From: Judith Ward
Sent: 15 July 2021 14:13
To: Rebekah Morgan
Subject: 21/02177/DISC Graven Hill Development Company. Roundabout to GH and Wretchwick Green, Bicester

Judith Ward
Landscape Planning Officer
Cherwell District & South Northants Councils

**Drawing Status**  
PRELIMINARY

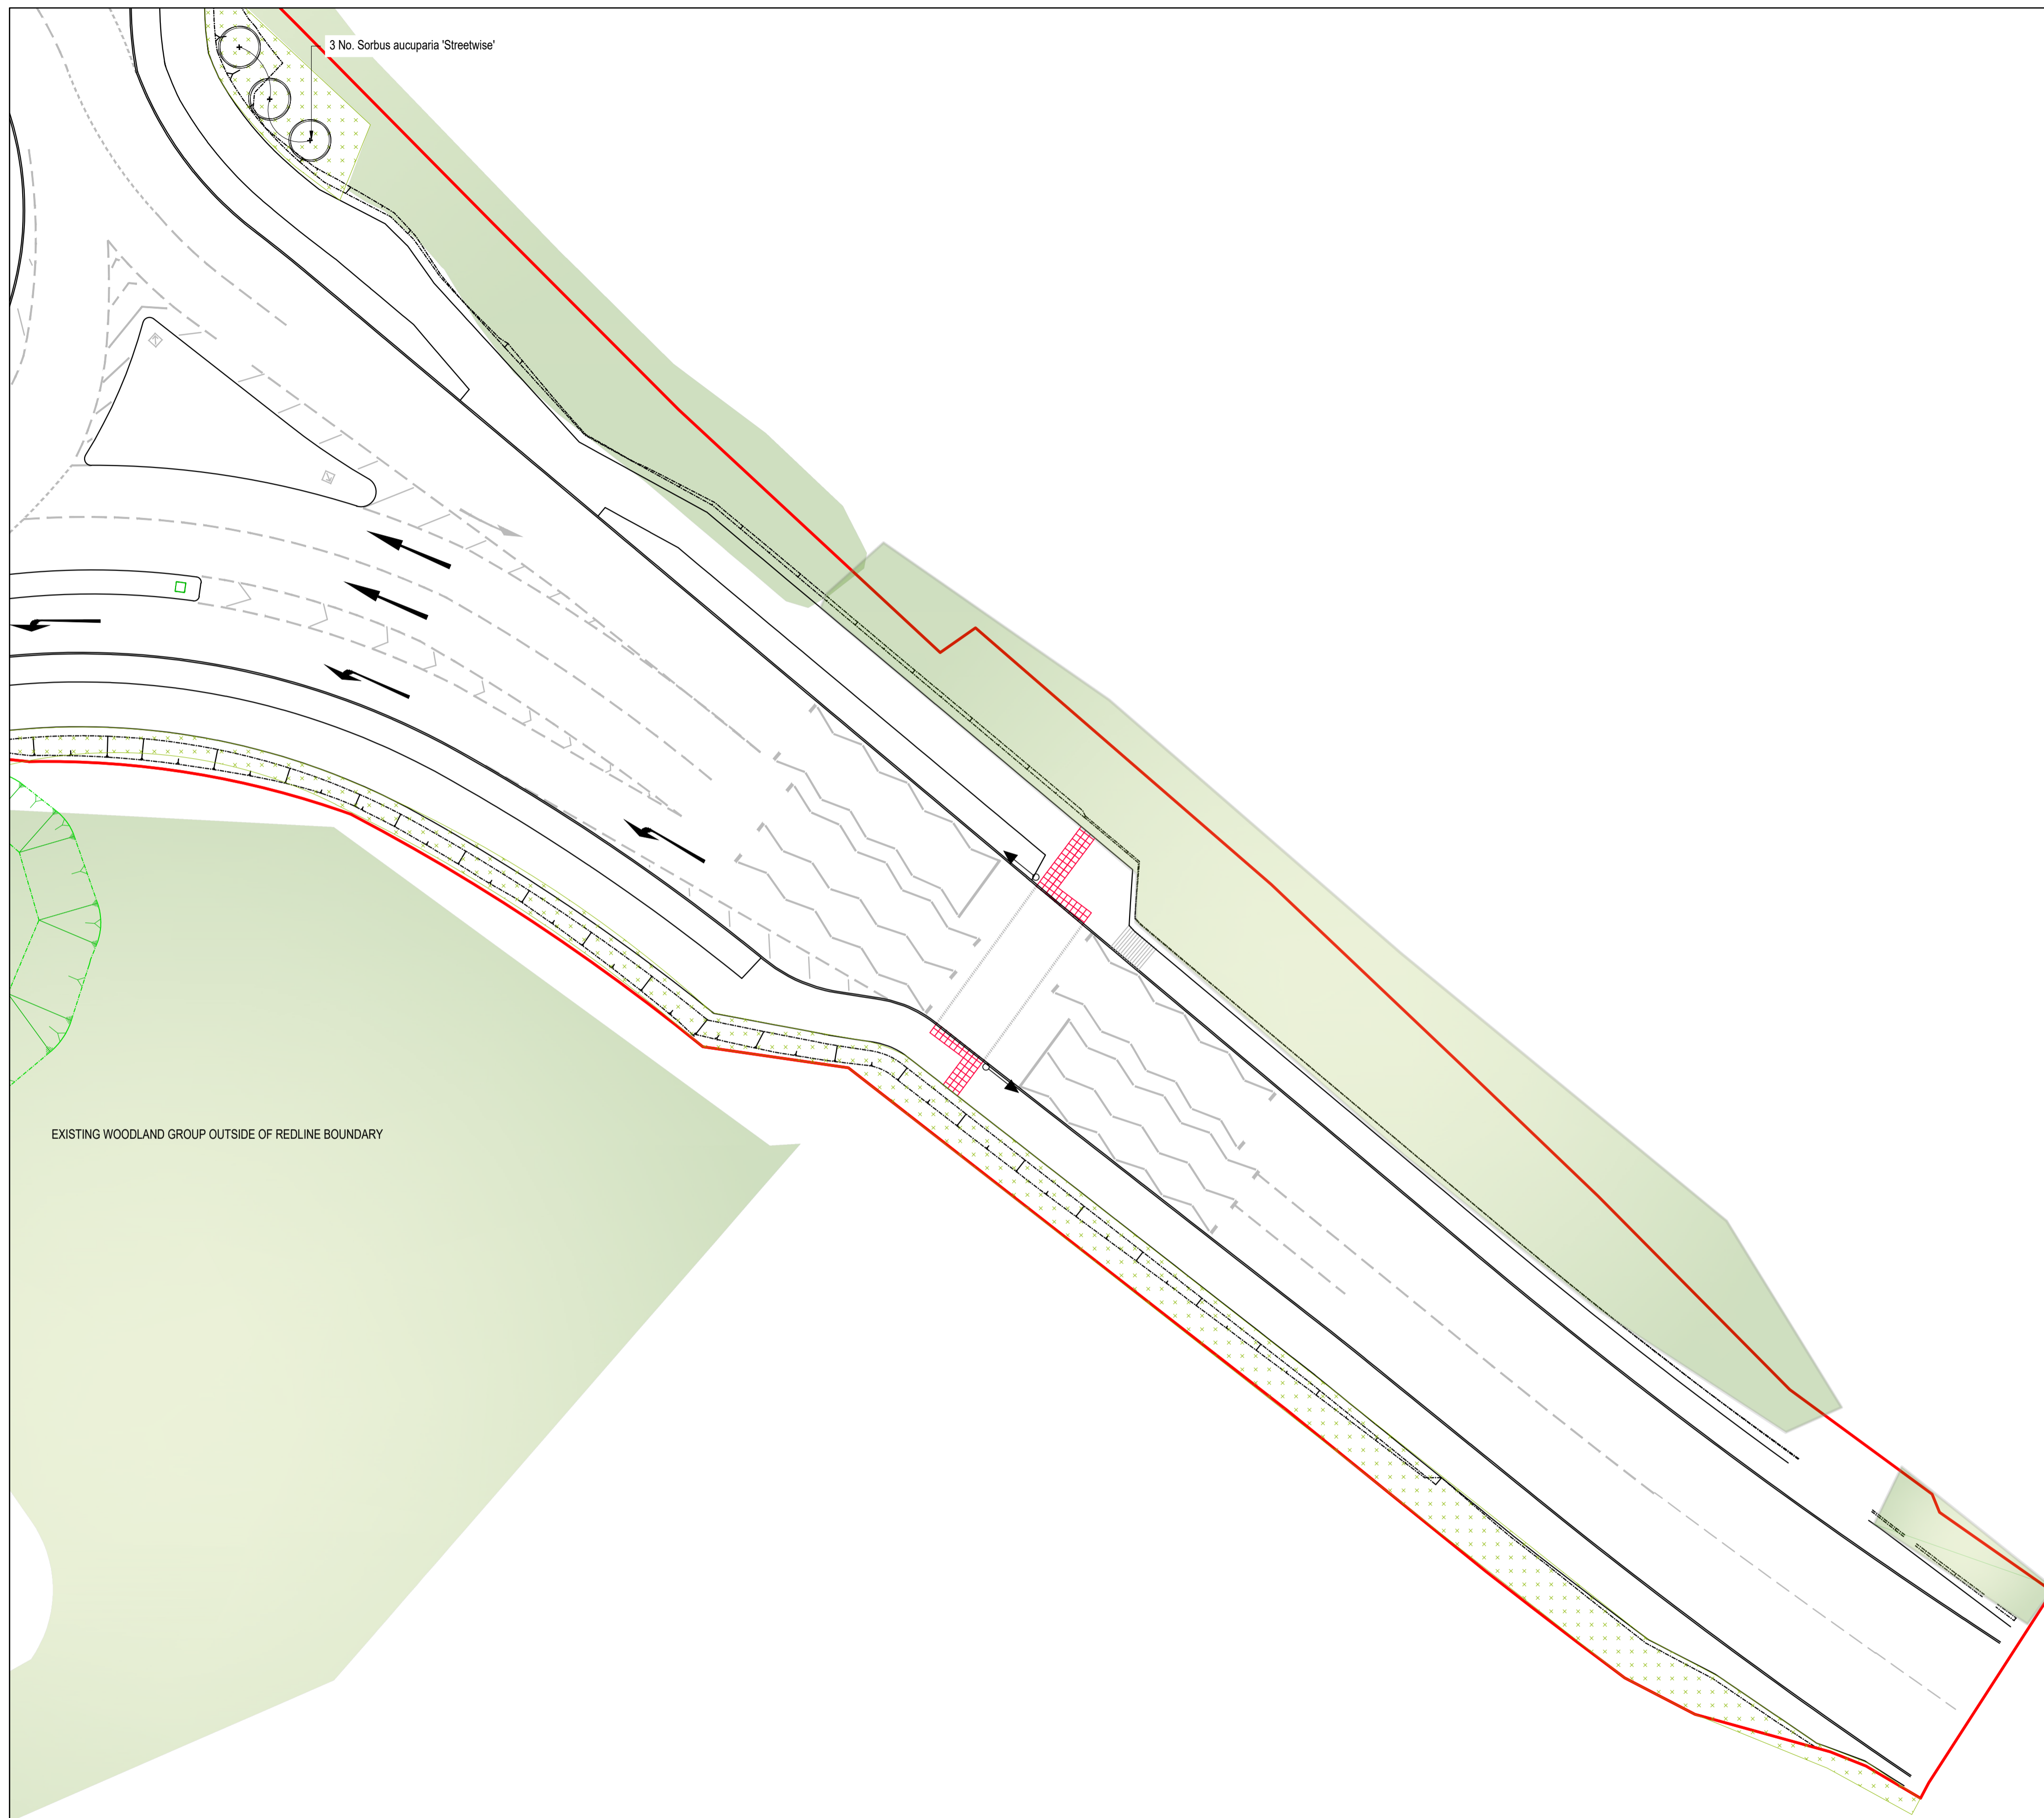
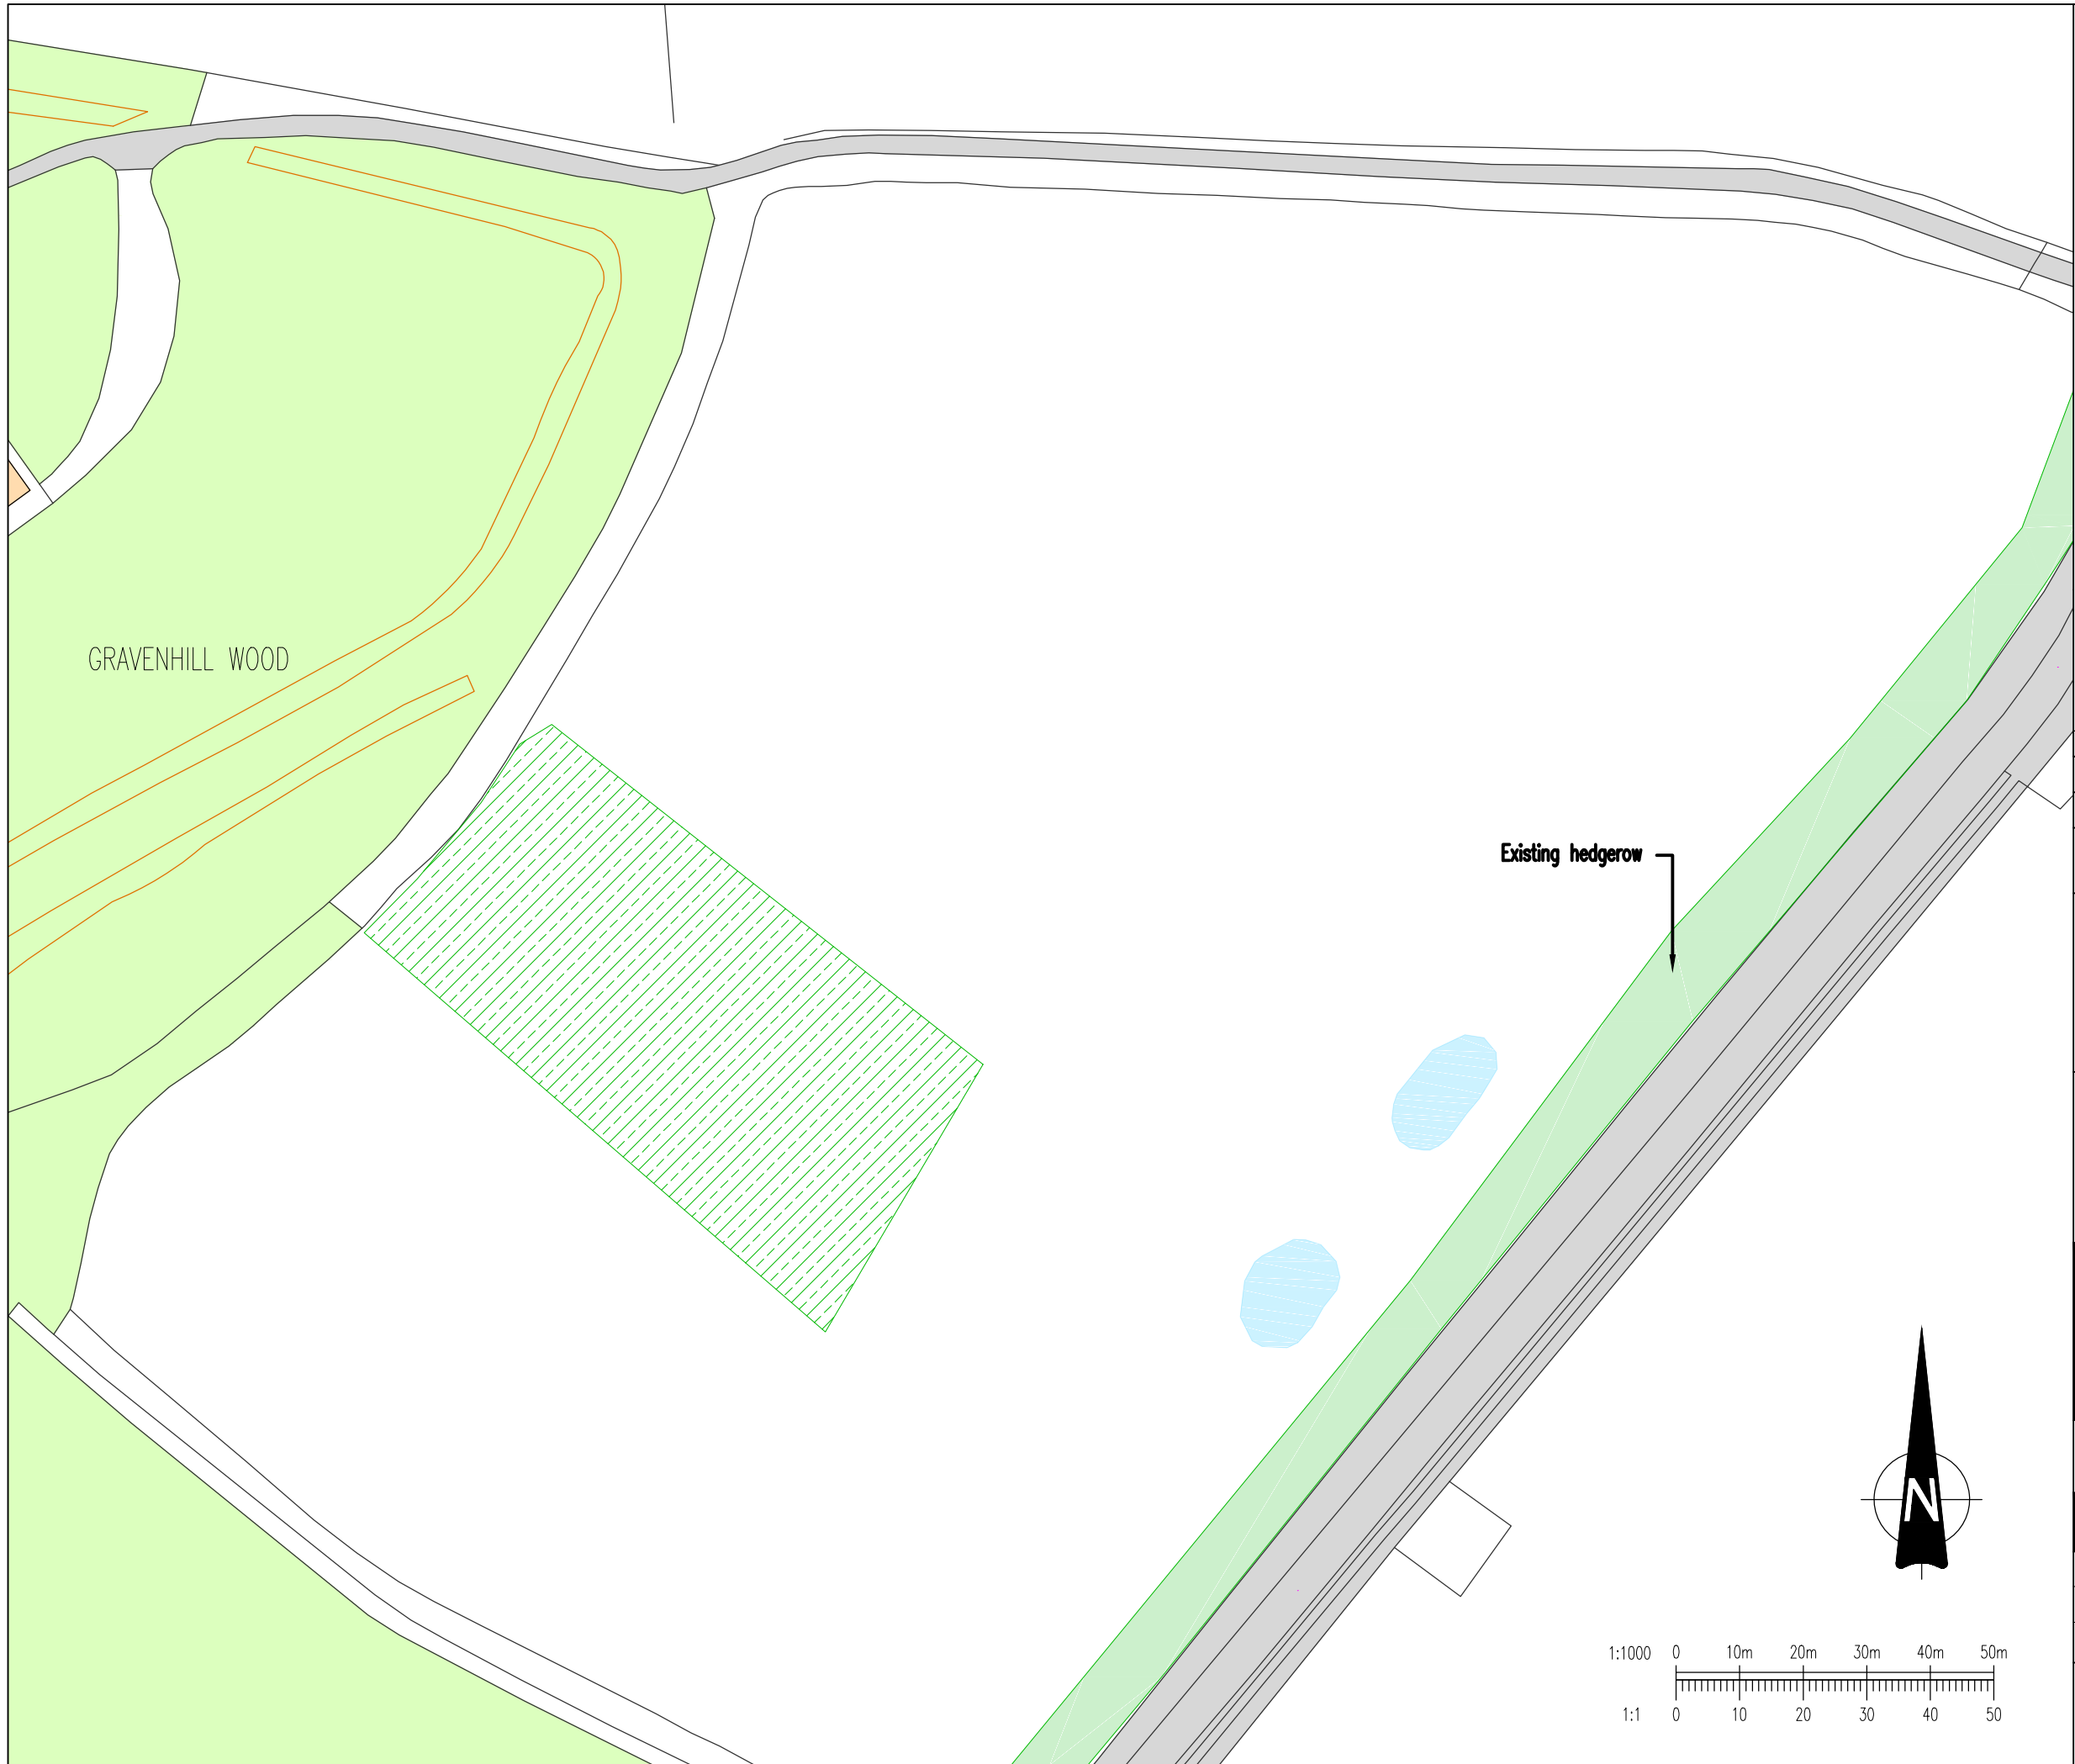
Prunus don't grow well on the heavy clay soil which we have at GH. An alternative tree should be specified.

Tree sizes are far too small for a key entry point to the site.

Cornflower annuals will need re-seeding every year so are unsuitable. We don't have the budget to do this. A wildflower seed mix with perennial wildflowers should be specified.
